# SSD 16\_7894: CHAU CHAK WING MUSEUM UNIVERSITY OF SYDNEY, CAMPERDOWN CAMPUS

UNIVERSITY OF SYDNEY RESPONSE TO SUBMISSIONS

18 DECEMBER 2017

Drawing Title
**GENERAL ARRANGEMENT
PLAN
LOWER GROUND LEVEL - 1**

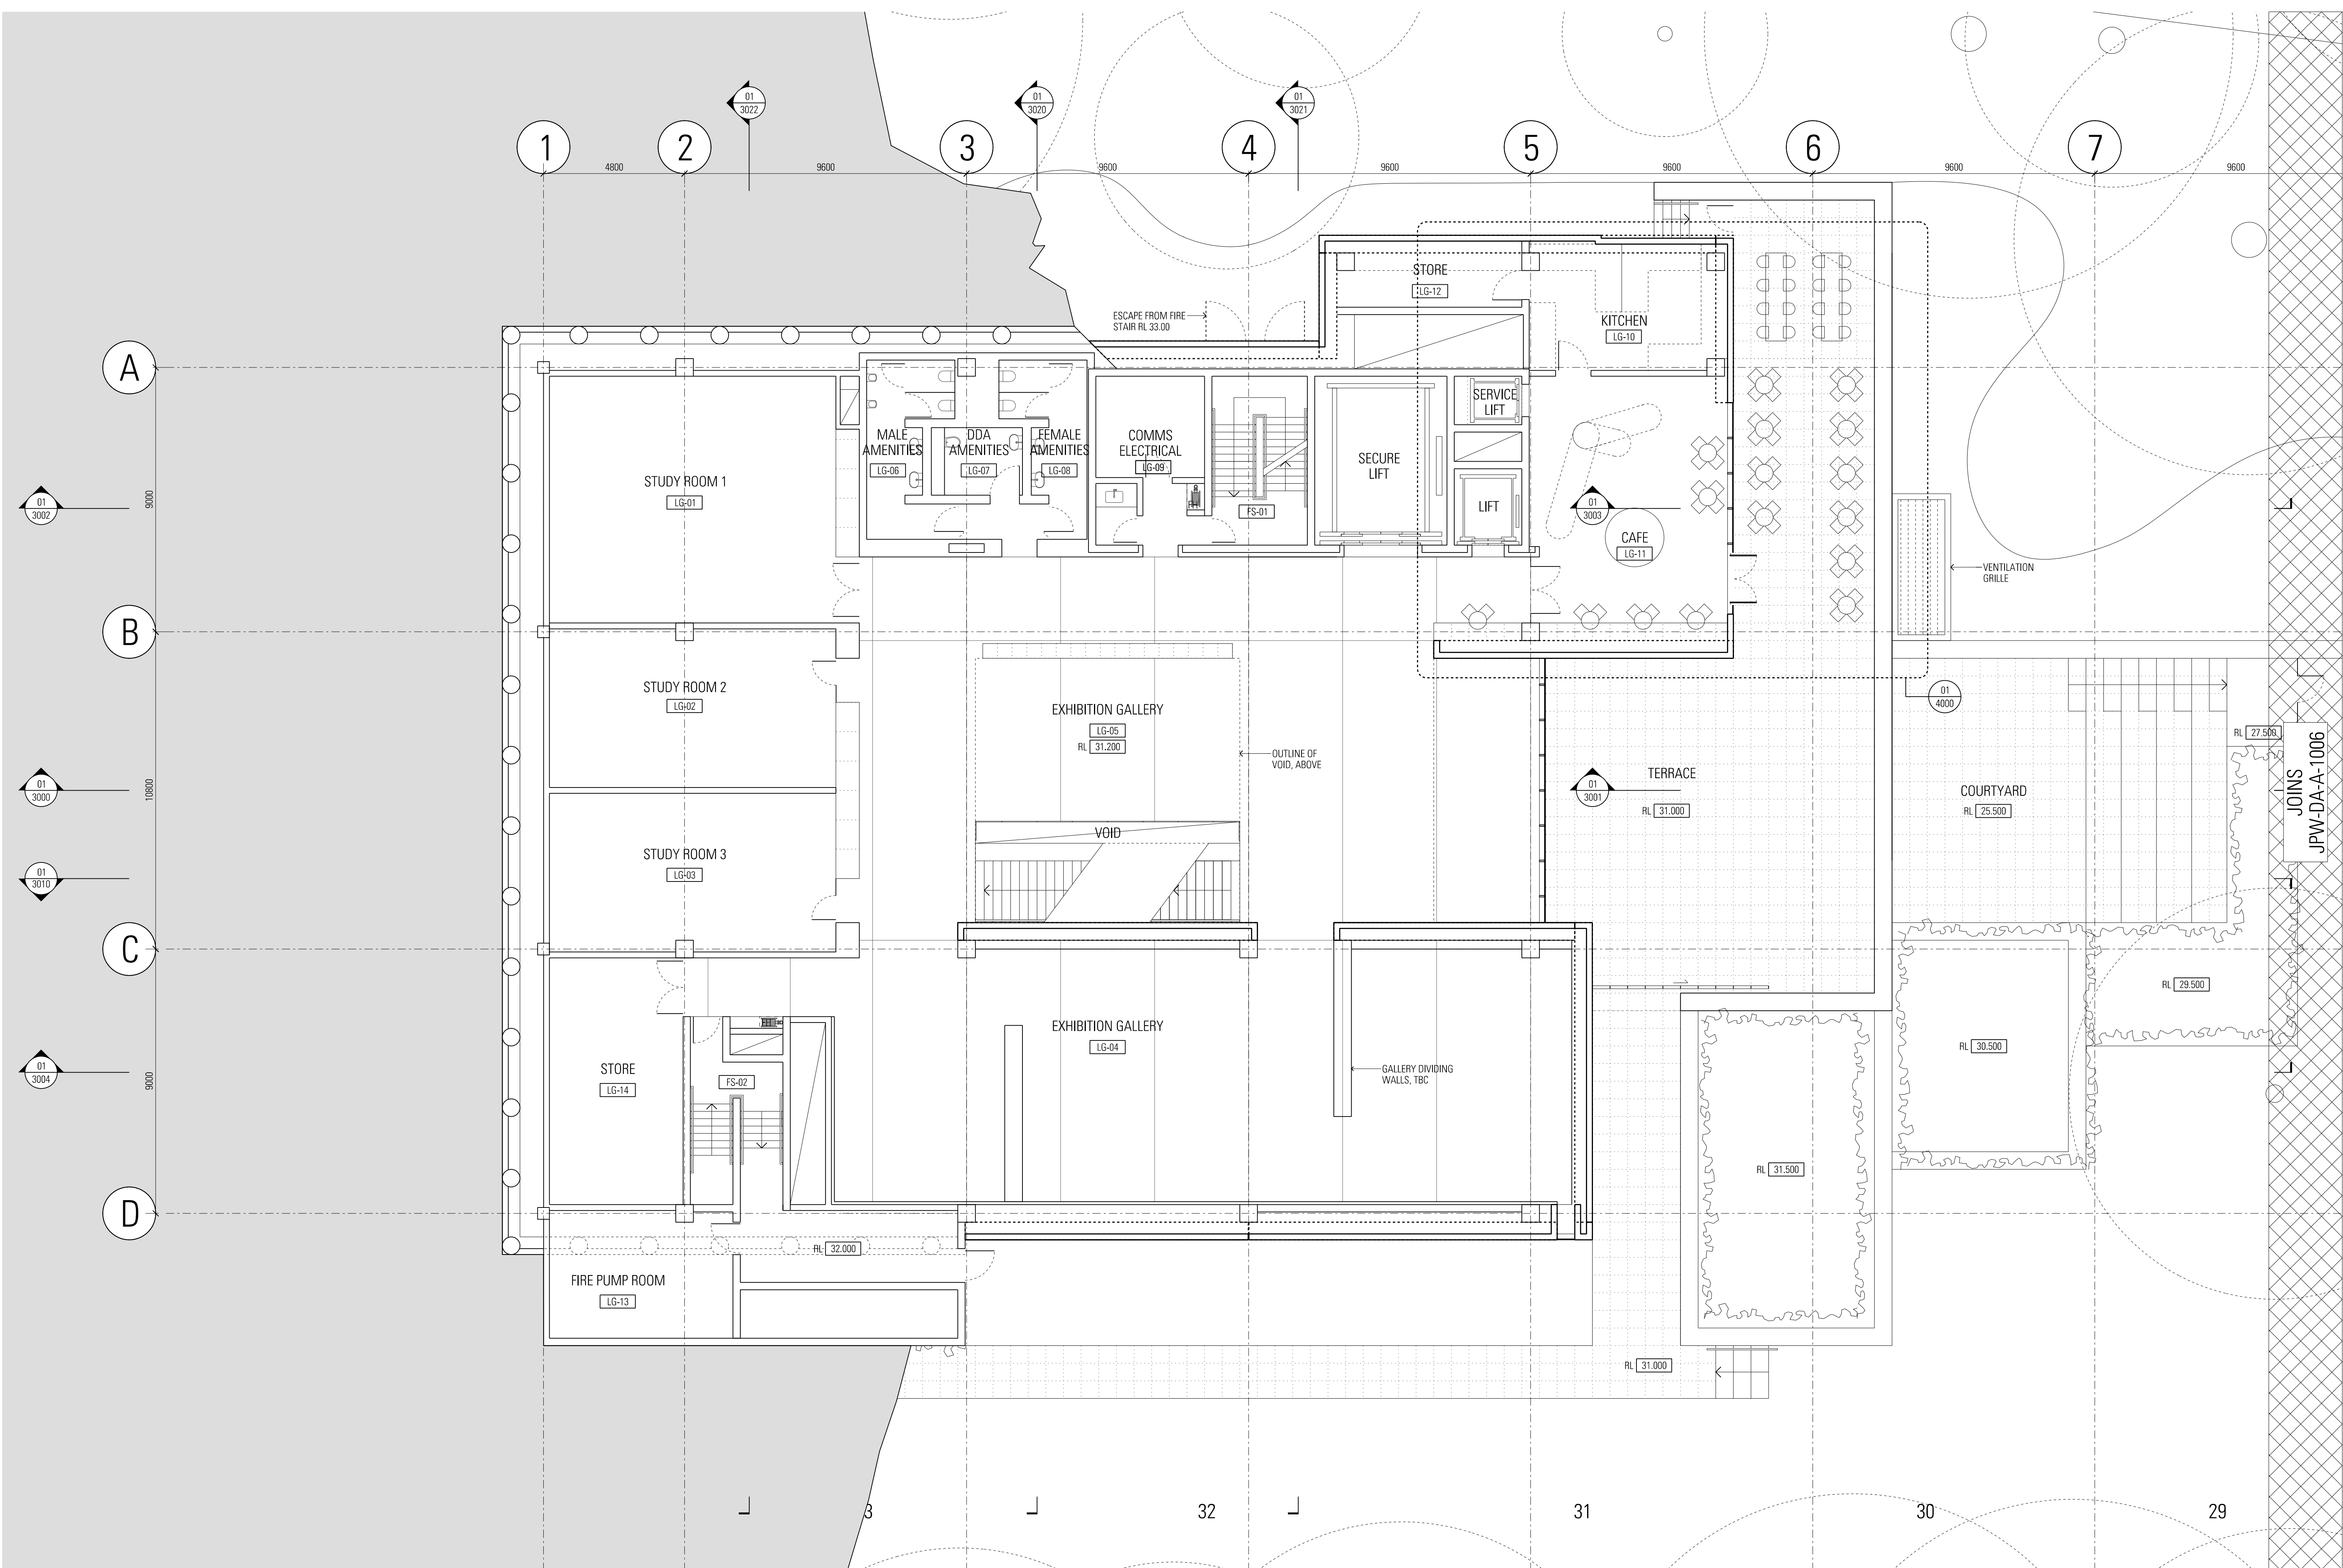
SSD 16_7894 – CHAU CHAK WING MUSEUM	
DPE KEY ISSUE	UNIVERSITY PROJECT RESPONSE
<b>Built Form and Urban Design</b>  1. The potential for a more interactive public domain along the southern elevation at ground level (at the western end of the elevation) and at lower ground level 1 (at the eastern end)	<p><b>URBAN DESIGN GENERALLY</b></p> <p>The site location, directly adjacent to one of the most important vistas on campus, has directly informed the building design. Similarly, the landscape character of the site, with stands of significant trees along the north and south sides, and large areas of lawn and ivy groundcover, have been influential forces in determining a design solution that is responsive to place and purpose.</p> <p>Each side of the building responds to the landscape setting in a unique way, acknowledging the orientation, solar access, views, topography, relationships to adjacent spaces on Campus, as well as the internal functions of the museum building.</p> <p>In this regard, the CCW Museum building is designed as an integral part of the landscape. From the outside, the ground plane is expressed as a series of terraces; an interplay of indoor and outdoor spaces.</p> <p><b>SOUTHERN ELEVATION</b></p> <p>The southern elevation is part of the setting for a key main axial vista between The Quadrangle and Victoria Park. Whilst the building defers to the fig trees along University Avenue as the primary definition of this vista, the design also anticipates the potential for a range of visual and physical connections between the building and the public domain around it.</p> <p>The tree canopies form a clear understory that allows views from the pedestrian pavements along the south and north sides of University Avenue, whilst the canopies of these trees almost entirely screen the building's upper storey from these locations.</p> <p>The building design incorporates a glazed slot between the upper level and the ground plane, which can be enclosed or opened to public view depending on internal display requirements.</p> <p>It is important to recognise that the majority of items that make up the University's collections are relatively small, and therefore difficult to identify at a distance.</p> <p>Like many other cultural buildings that rely on the tight control of internal environmental and atmospheric conditions to protect sensitive collection items, the opportunities for large glazed openings are limited, as the ingress of light and the potential for temperature and humidity variation close to the external perimeter of the building is problematic for the long term display and protection of artefacts. Also, to provide the required levels of security to protect the \$250m+ in Museum collections the building has been designed with one point of entry and egress as this provides greater physical protection and monitoring of patrons.</p> <p>This consideration, along with the views framed by the existing trees, limit the opportunities for conventional activation initiatives along the southern façade. However, the building siting anticipates potential future enhancements to the public domain and landscape spaces around the building as the University acquires and commissions major new art pieces that can be installed outside, or projected onto the upper level facades at night time.</p> <p>From the inside, including along the southern elevation, the public spaces are visually and/or physically connected to the outside, with framed views of the parkland and vistas of the City and University Place to guide wayfinding and embrace the unique character and sense of place of this part of the Campus.</p>

SSD 16_7894 – CHAU CHAK WING MUSEUM	
DPE KEY ISSUE	UNIVERSITY PROJECT RESPONSE
	<p>The sloping site provides direct indoor-outdoor connections both visual and physical on many floors, including:</p> <ul style="list-style-type: none"> <li>• Arrival Forecourt with ground floor foyer as point of welcome, information and entry (Western side)</li> <li>• Lower Terrace and Café as an exhibition ‘break’ and space for functions and events (Eastern side)</li> <li>• Gallery Courtyard to Level 1 Gallery, as outdoor learning and exhibition space (Eastern side)</li> </ul> <p>The ground line along the southern elevation is steep following the existing contours which drop 5 metres from west to east.</p> <p>The western end is part of the Arrival Forecourt, where the southern corner is the school groups gathering space close to the museum entrance off University Place. The eastern end leads to the café terrace seating area with views and aspect across Victoria Park.</p> <p>The public domain surrounding the building is highly accessible and welcoming, consisting of a series of ‘outdoor rooms’, open gathering and seating spaces. These have been further developed since the initial submission.</p> <ul style="list-style-type: none"> <li>• Northern Gathering Space – located on the sunny North West under a major existing fig tree.</li> <li>• Garden Walk – this is the existing footpath with new ‘bush library’ plantings and seating.</li> <li>• Eastern Lawn – as a continuity of the parkland linking to Victoria Park.</li> </ul>
